Ribble Valley Borough Council  
Council Offices  
Church Walk,  
Clitheroe  
Lancashire  
BB7 2RA

Phone: 0300 123 6780  
Email: [Kathryn.Walsh@lancashire.gov.uk](mailto:Kathryn.Walsh@lancashire.gov.uk)  
Your ref: 3/2025/0190  
Our ref: 3/2025/0190/HDC/KW  
Date: 24 March 2025

**Location:** 10 Barker Lane Mellor BB2 7ED

**Proposal:** Proposed demolition of existing single storey porch/ bedroom/ utility, car port, conservatory and detached garage. Construction of two-storey side extension, single storey rear extension and new front porch. Replacement windows and doors, alterations and resurfacing of driveway and installation of solar panels and render finish to SE side elevation.

1 Proposed Ground floor  
1:50

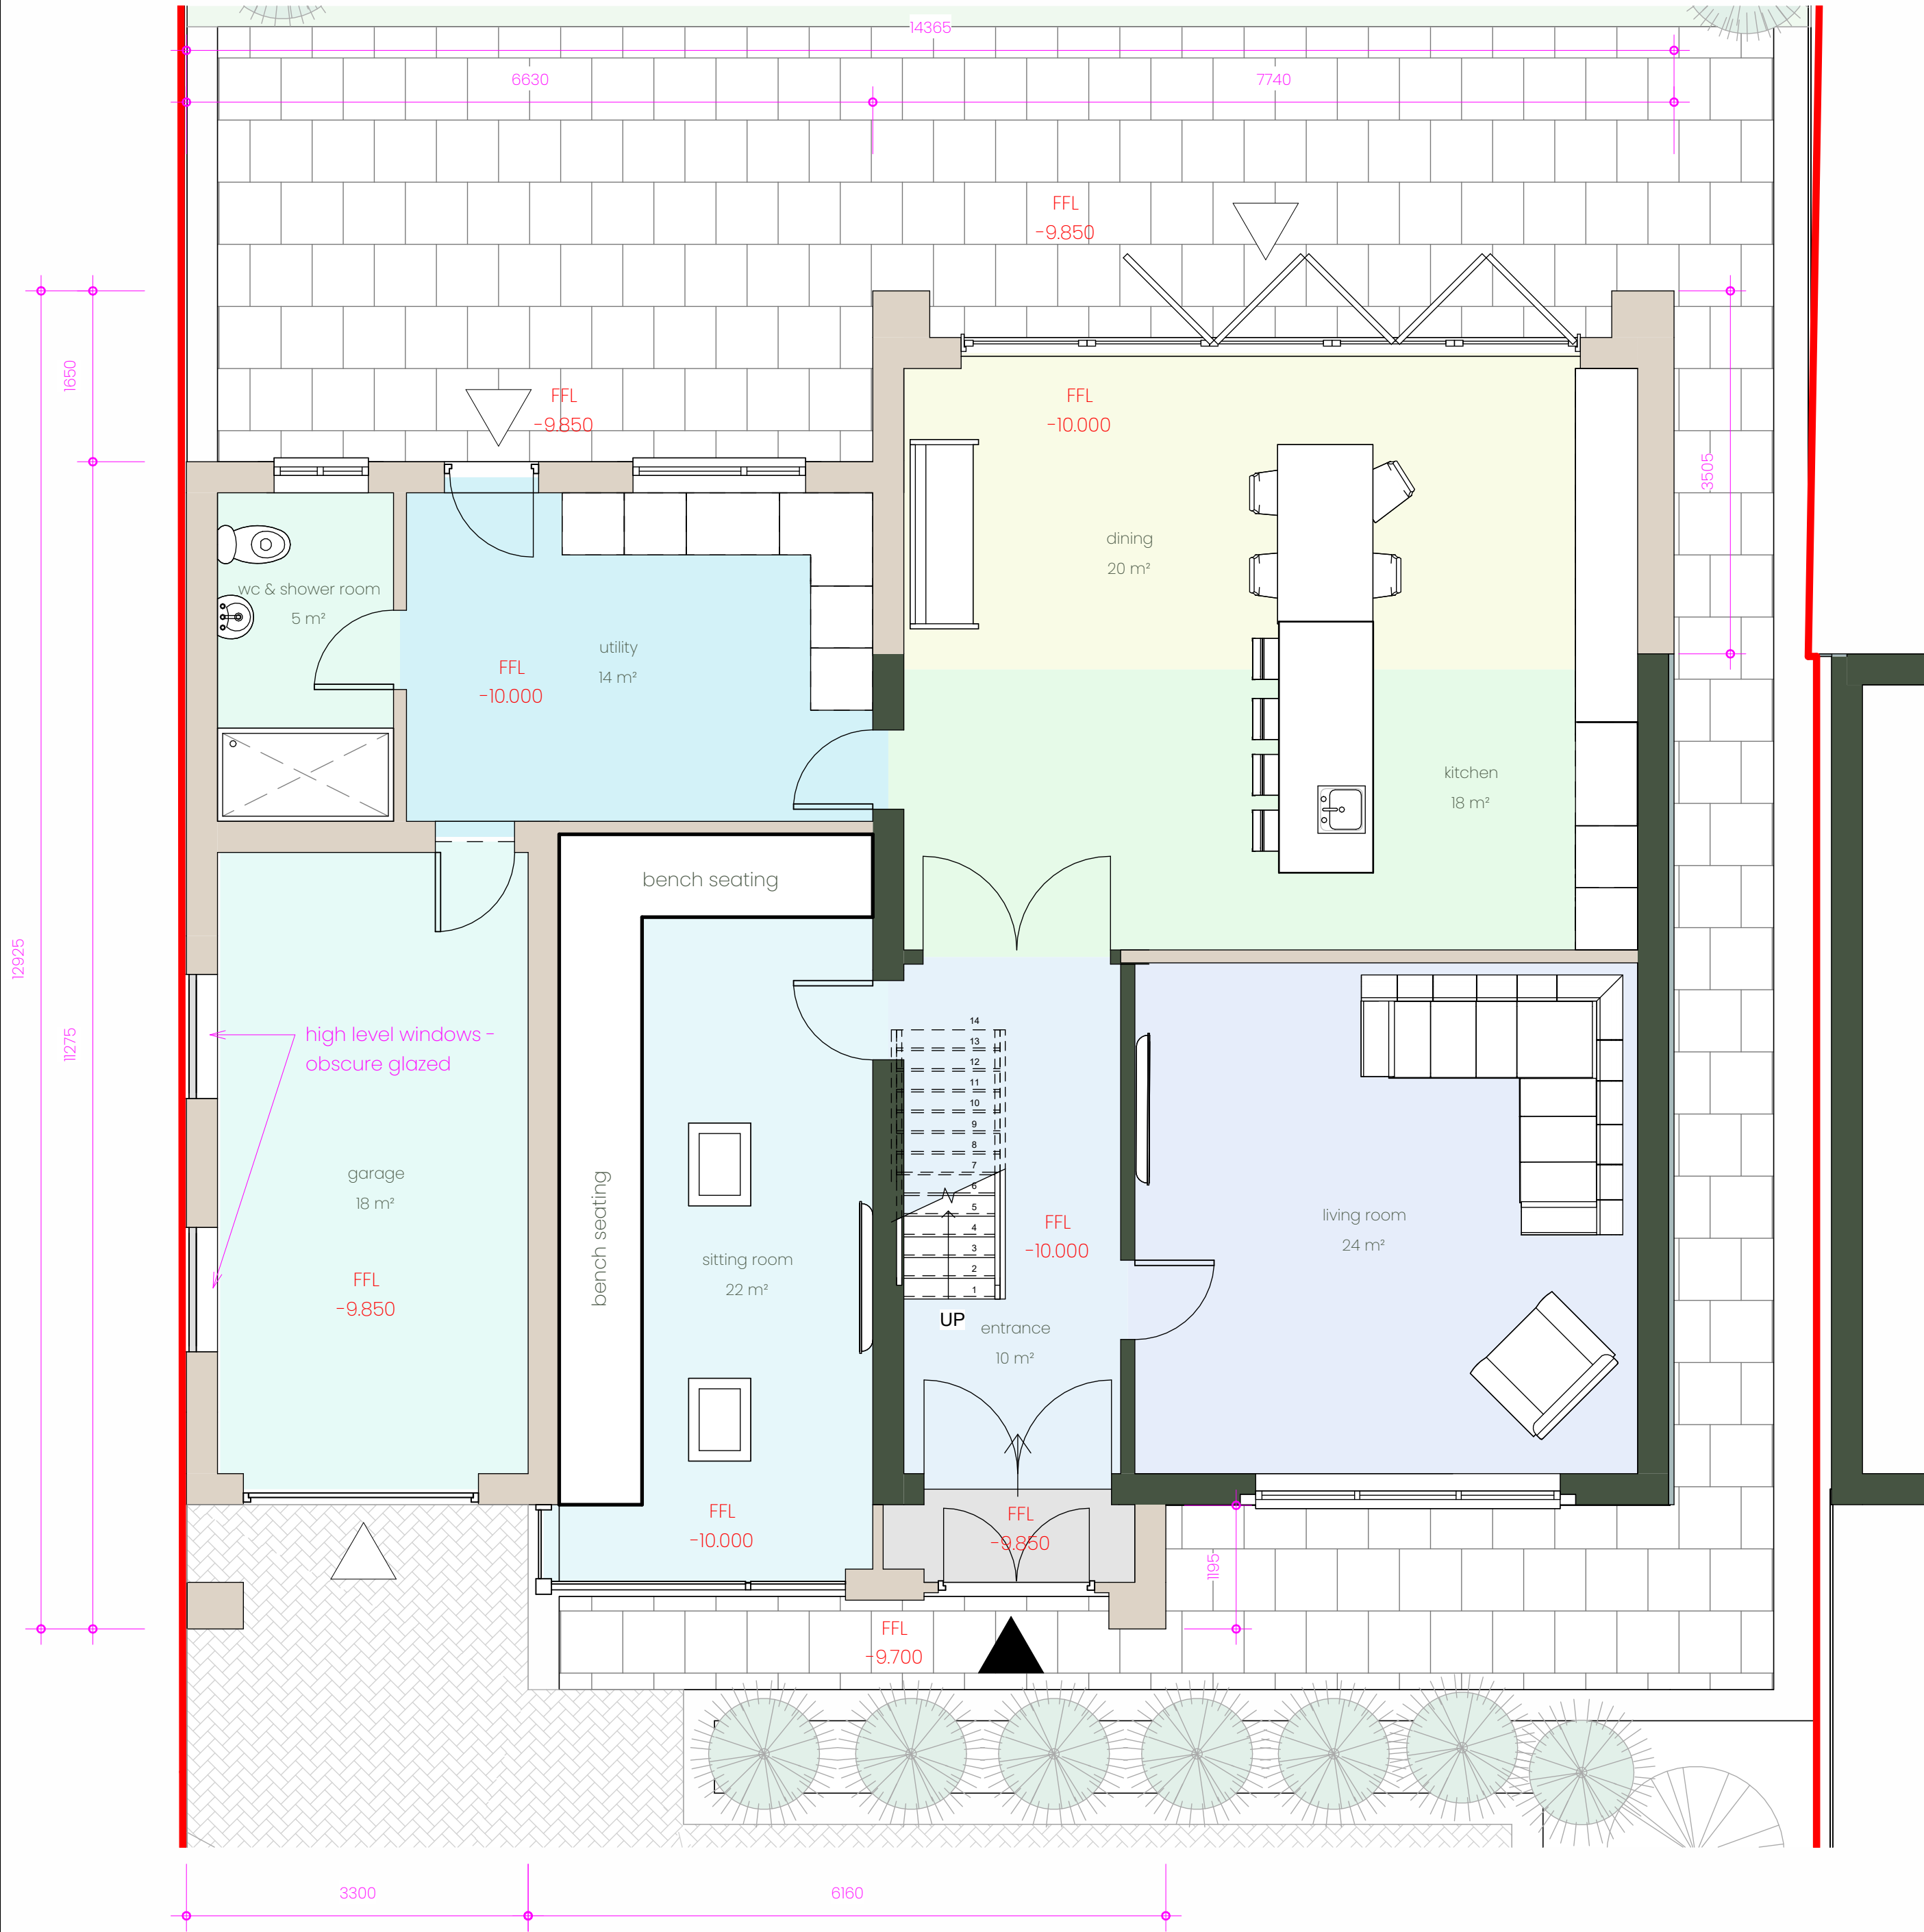
The recommended minimum internal dimensions for a single garage size is 6m in length and 3m wide. The recommended distance of 6m is based on the length of a large family car (Ford Mondeo Estate 4.58m long), clearance at the rear of the car (200mm), overhang of the garage door (600mm) and room to stand in front of the car and open/close the garage door (600mm). The LHA has reviewed the proposed floor plan, drawing A1.4 and note that the garage have been designed to an acceptable internal size to provide parking.
